**KIRKLEES METROPOLITAN COUNCIL
INVESTMENT & REGENERATION SERVICE**

DELEGATED DECISION TO DETERMINE PLANNING APPLICATIONS

Reference No:	2026/62/92403/W
Site Address:	38, Heights Drive, Linthwaite, Huddersfield, HD7 5SU
Description:	Erection of side extension
Recommending Officer:	Dhruv Gopalakrishnan

DECISION – CONDITIONAL FULL PERMISSION

Proposed front/south facing elevation (1:100)

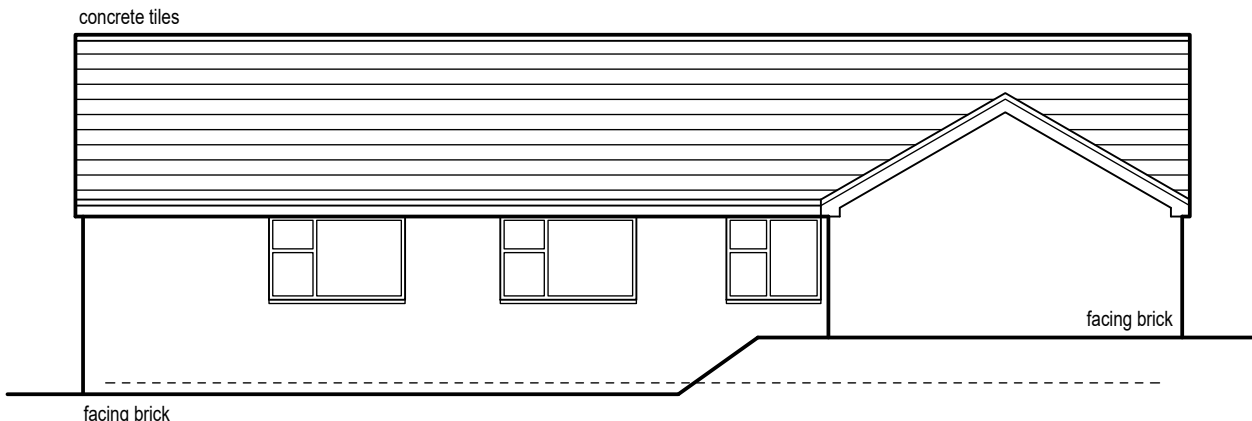
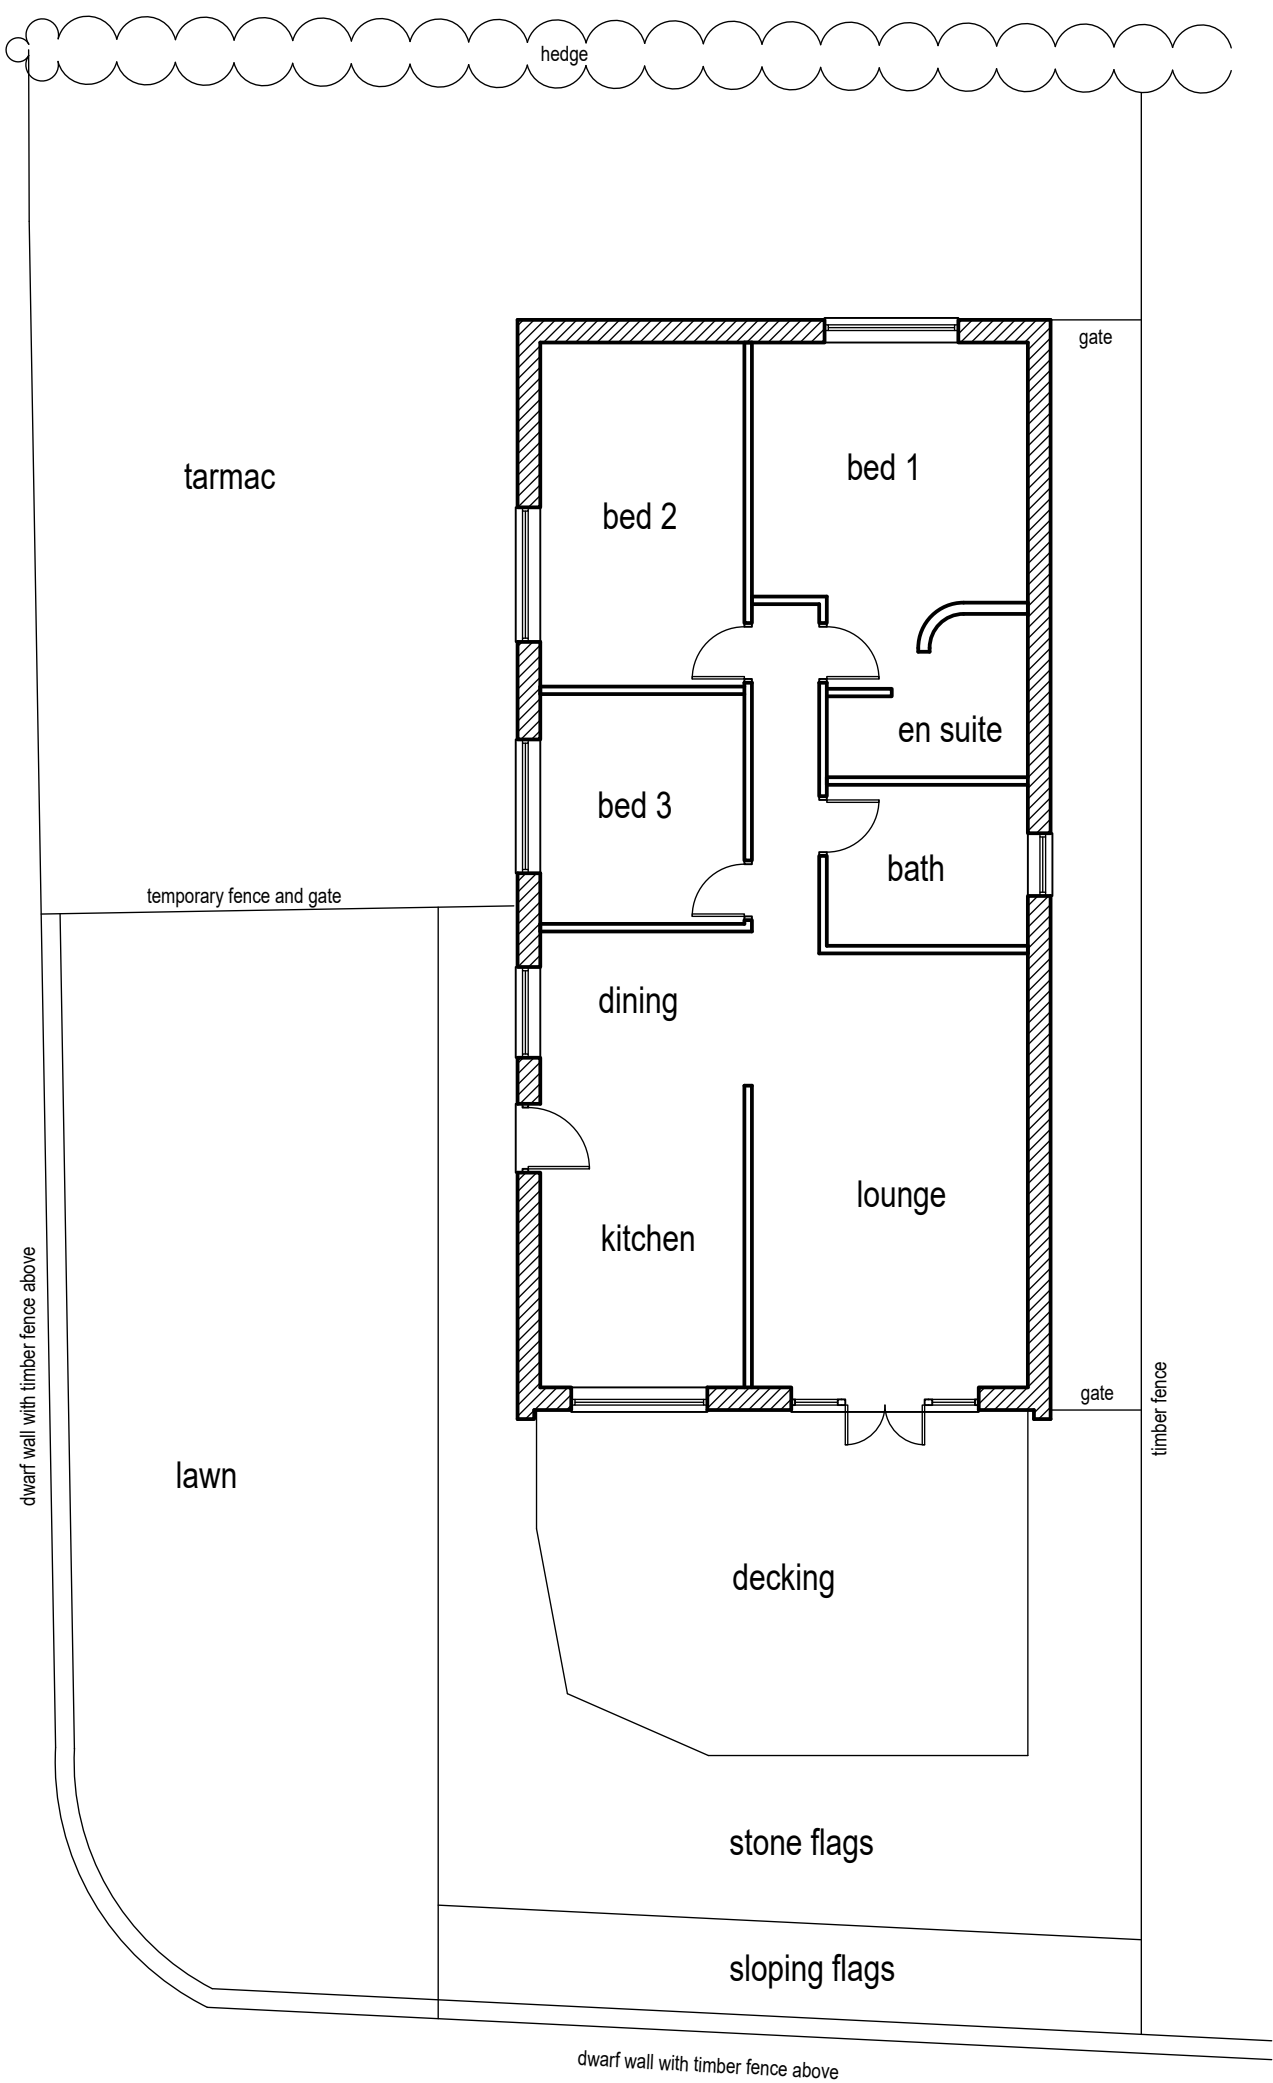
The applicant's agent was contacted with a recommendation made to give consideration to setting the proposal back by 0.5 metres from the south face of the dwelling. The applicant's agent has pointed to a number of points considered to be in justification of the scheme as proposed, which are taken into account in assessing this application.

The extension is mostly in accordance with the SPD guidelines for single storey side extensions. The height, width and material finish of the proposal is appropriate for the host dwelling. A gap of approximately 4.9 metres would be retained with the boundary, which would be sufficient to avoid any harmful impacts to visual amenity and significant losses to curtilage area. The proposed positioning and size of the roof will also ensure that the extension will remain subservient in appearance to the host dwelling. However, the set back of the extension from the original building line is not in accordance with the SPD as the proposed side extension would be aligned with the south face of the dwelling.

Notwithstanding the aforementioned merits of the proposal, the extension is still deemed acceptable in this case. A sufficient gap, measuring 8 metres, between the south face of the dwelling and site boundary will be maintained after development as this area would not be built upon. This would ensure provision of an appropriate visual break with the development. Given that the dwelling is of a detached nature

and the site does not form part of a uniform street scene, a 500mm setback is not essential to provide a visual break. Sufficient justification is therefore considered to be present in this case in relation to the fact the proposal is flush with the wall. A condition requiring matching materials is recommended.
